From: Paul Troop [REDACTED]
Sent: 31 August 2023 15:27
To: Planning; Suzanne Taylor; White, Joy - Oxfordshire County Council
Cc: chair@bicesterbug.org
Subject: 21/04275/OUT Further Comments from Bicester Bike Users' Group

1. INTRODUCTION

2. INTERIM SCHEME (APPENDIX P, P.356)

Appendix D: Drawing 20300_SK_T007_P3

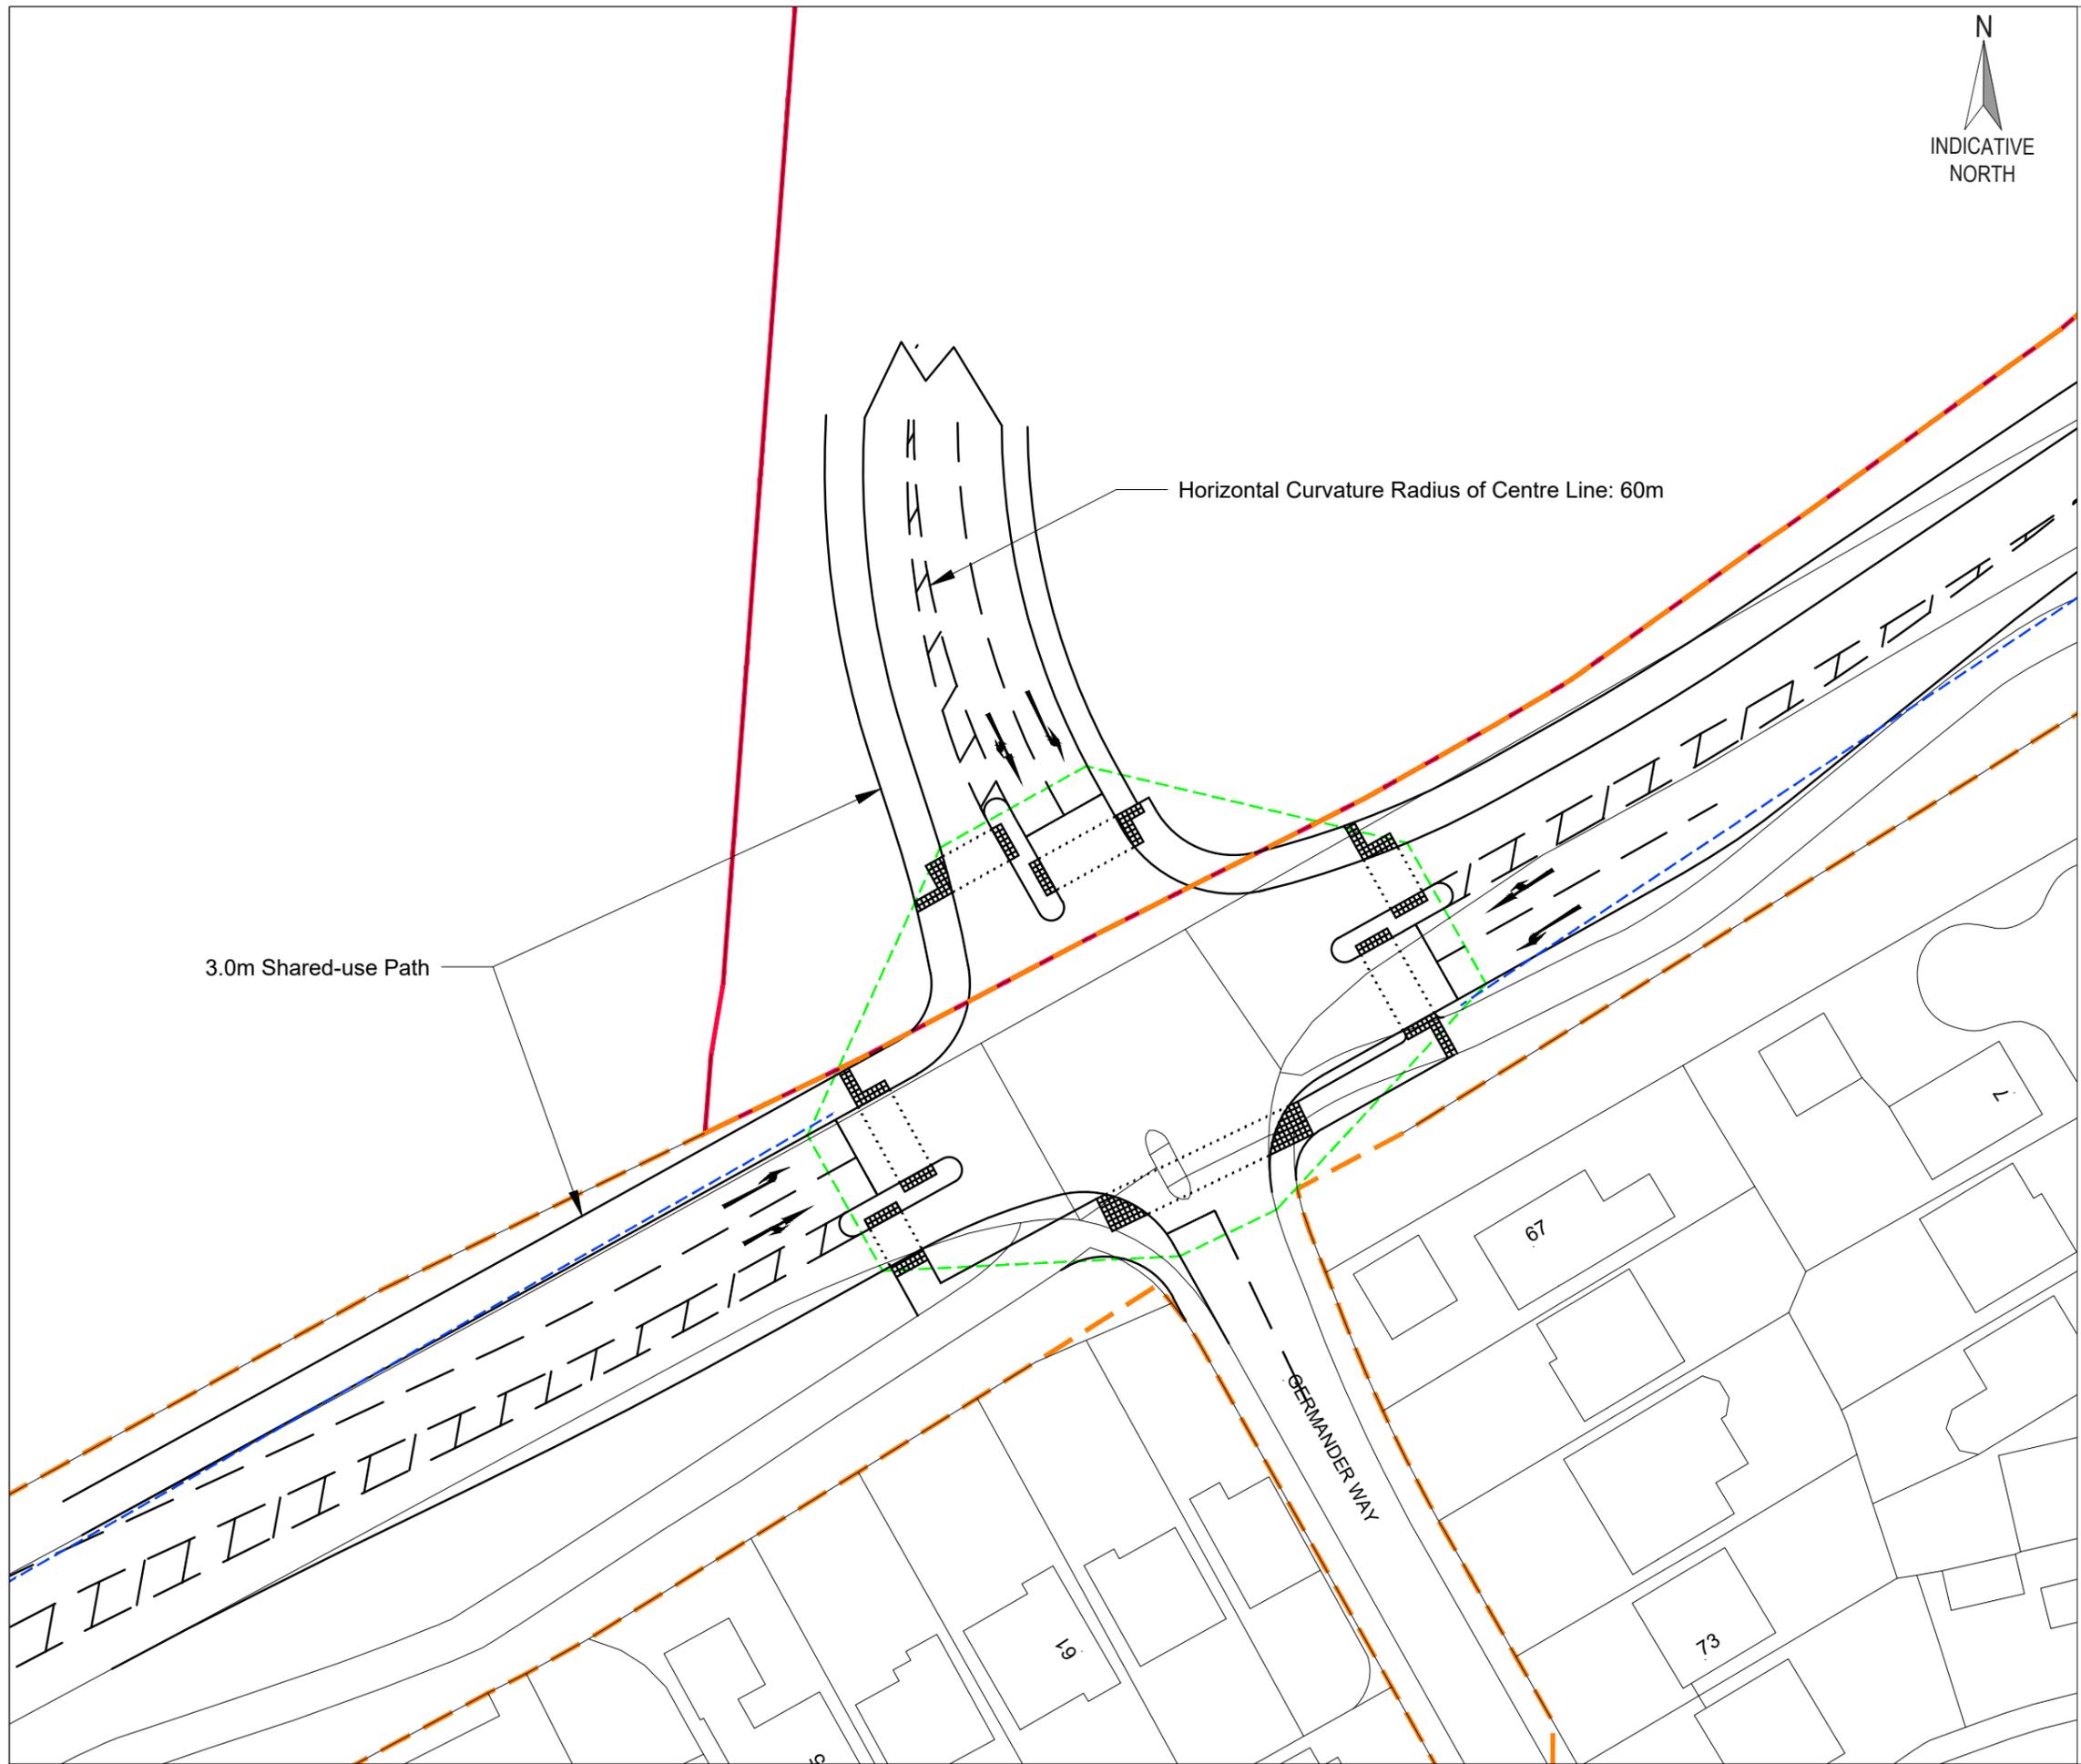
This junction is somewhat better, though the buffer to the motor vehicle highway appears rather narrow. A buffer of 1m+ would be preferable. The radii on the corners are also very tight, and should really be 15m+ as per LTN1/20.

Appendix E: Drawing 20300_SK_T_001_P3

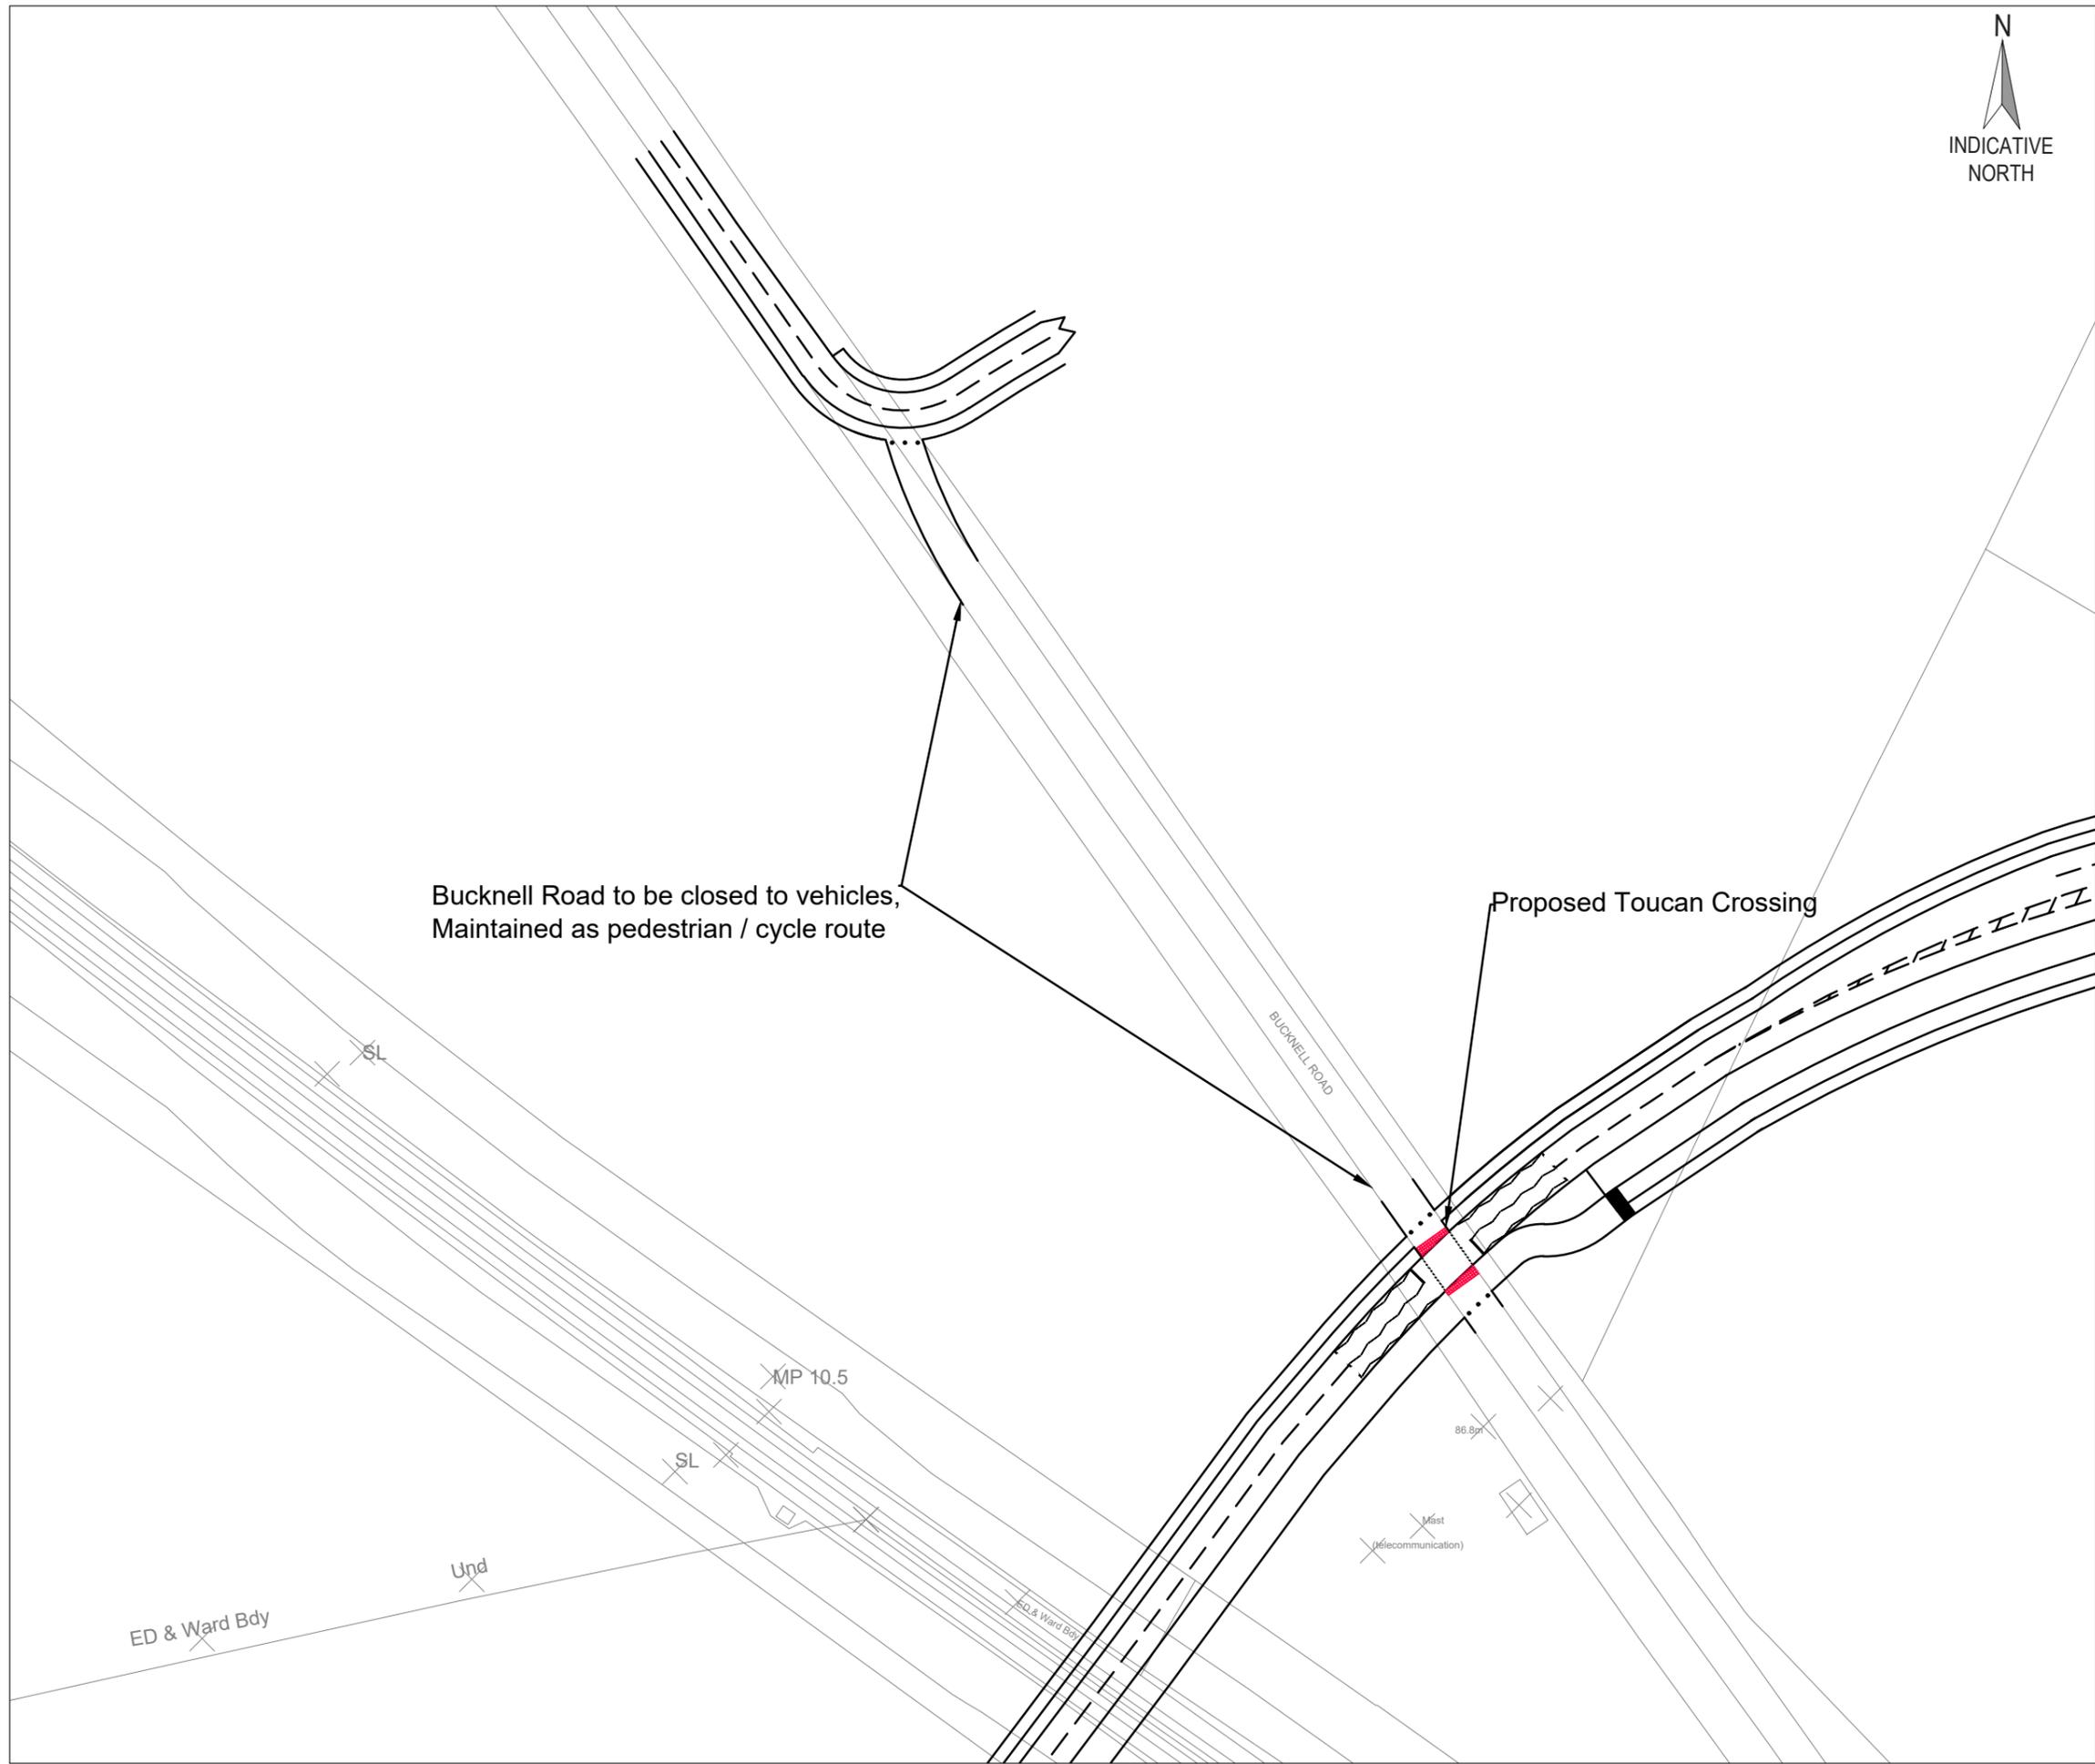
As above, this junction is better, but the buffers are rather narrow, and the corner radii are much too small and should be increased to 15m+.
